Community Environment Network Inc.

25th March 2020

Re. Northside Private Hospital, West Gosford (SSD 10159)

This is a submission from the Community Environment Network regarding the development application for the Northside Hospital, West Gosford development. In particular, this submission concerns the application for approval of a State Significant Development in accordance with State Environmental Planning Policy (State and Regional Development) 2011 and State Environmental Planning Policy (Gosford City Centre) 2018.

Figure 3: Building Height Diagram (Health Projects International, 2019)

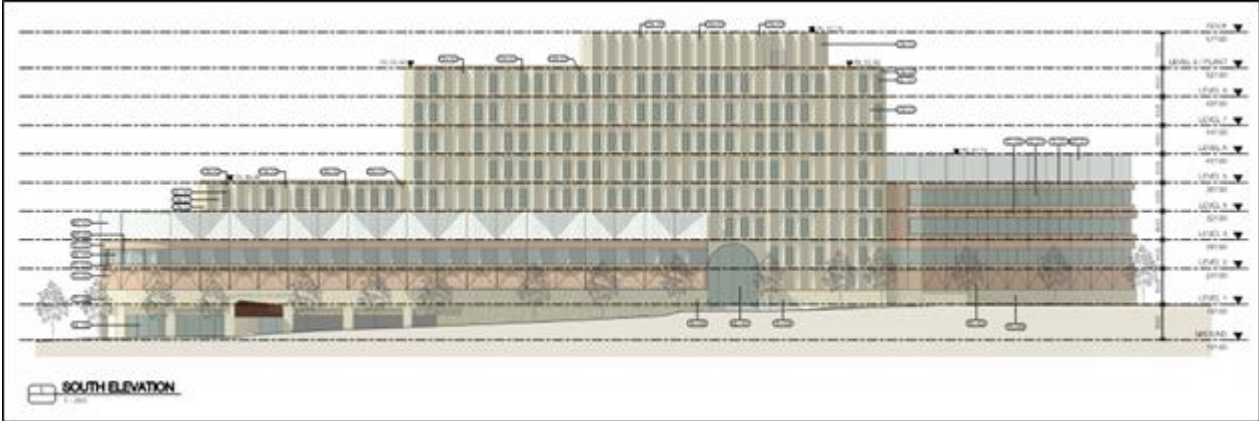
The SEPP recognised this by adopting a height limit of 12 metres for development along Racecourse Road. Even without the tower development for inpatients, the proposed hospital podium of 4 – 5 storeys will have a height of 23 metres, nearly double the height limit. It would be a gross abuse of the "design excellence" provision to allow another doubling of the building height to provide better views for the inpatients!
